## Response to A/110/21/PL McCarthy & Stone development of Chandlers Site.

### Assessment Against Angmering Neighbourhood Plan

Site Sections

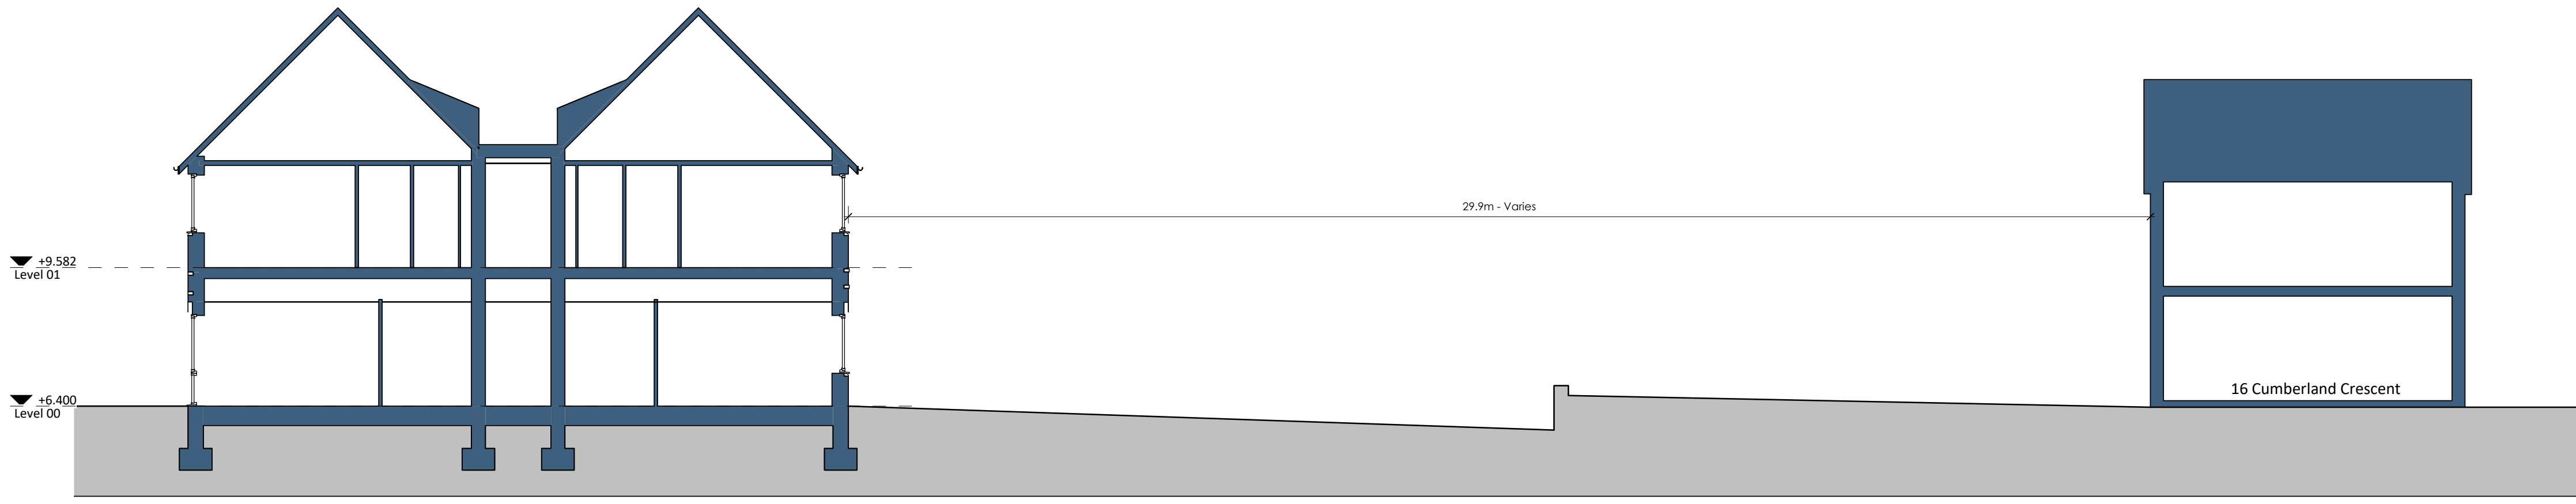
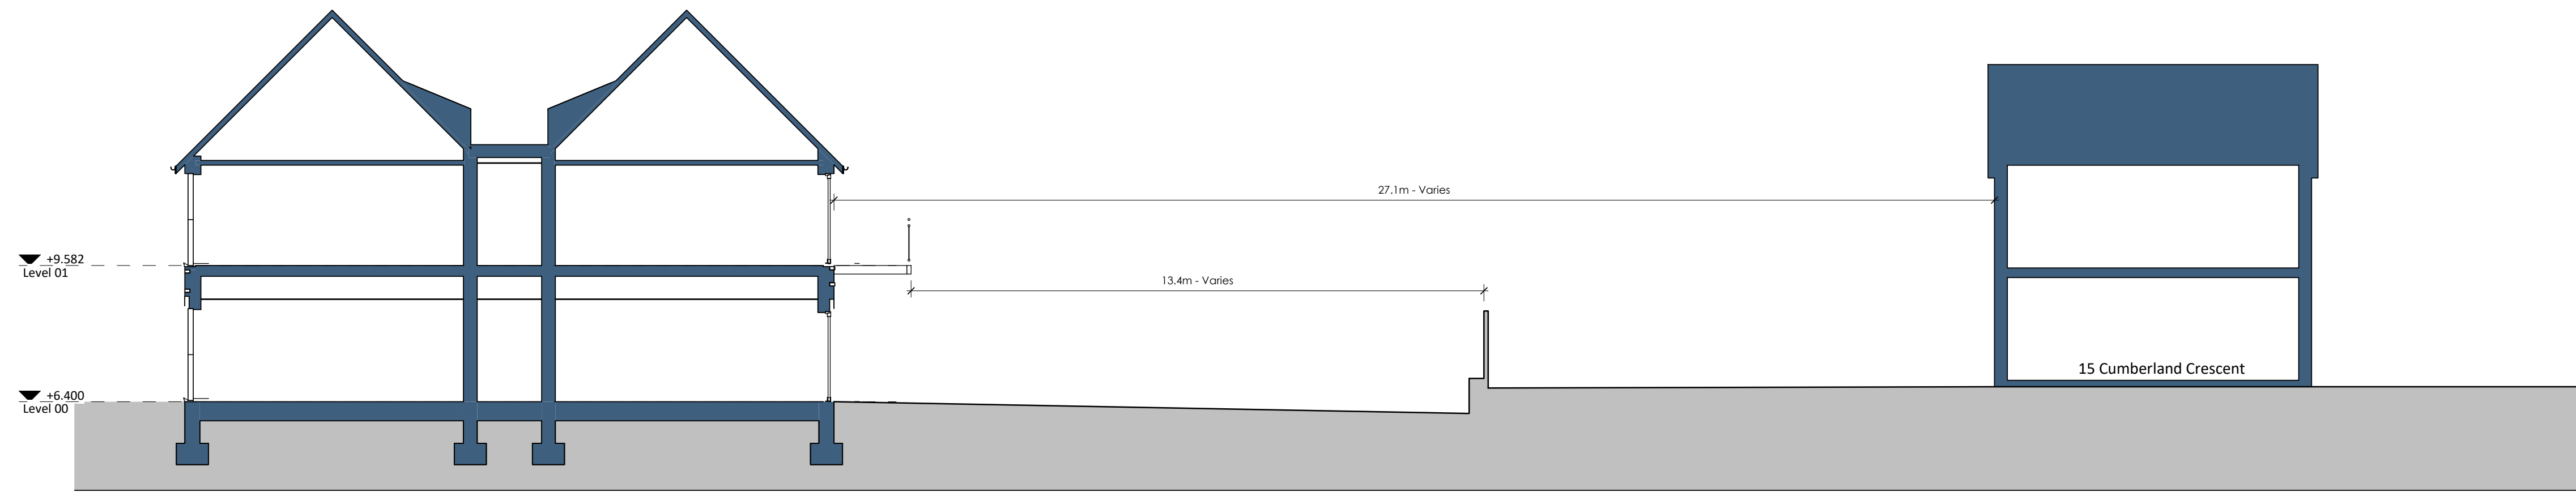
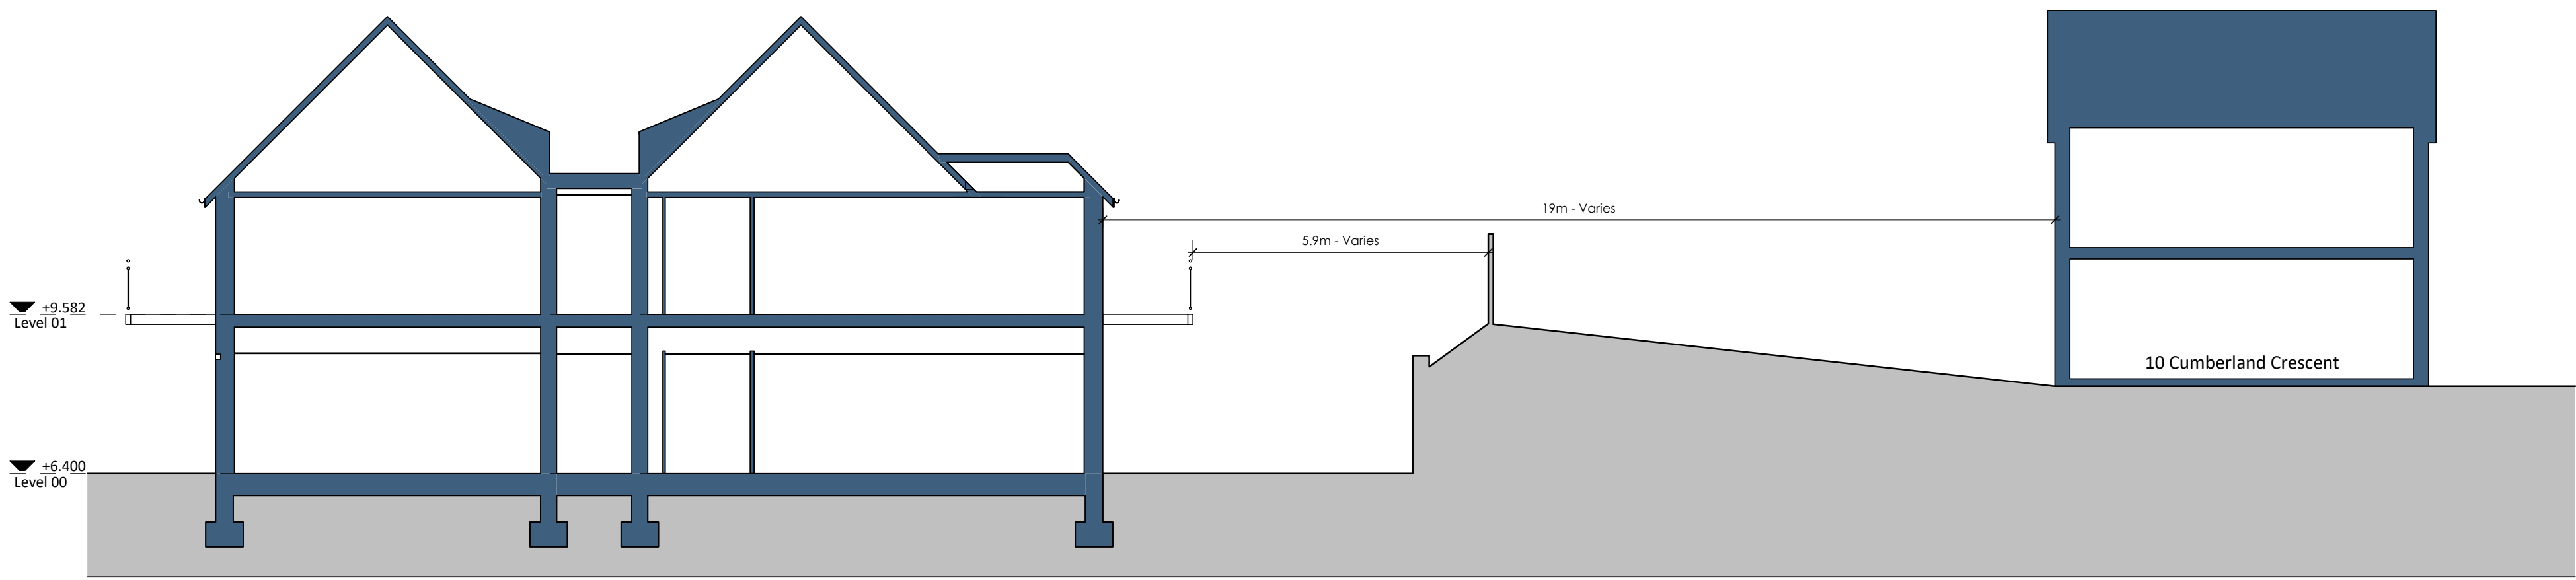
The density exceeds that of the surrounding area both in terms of number of dwellings and proportion of the site covered with buildings. The apartments are all two storey, albeit with high roof pitches which make the bulk of the buildings generally higher than surrounding dwellings. Ground levels to the rear (Cumberland Crescent) are higher which may mitigate this impact. However, the height of the building fronting onto High Street is particularly concerning given that this part of the site is in the Conservation Area and adjacent to a Grade II listed building 'Eachways', which the drawing below shows is much lower in profile.
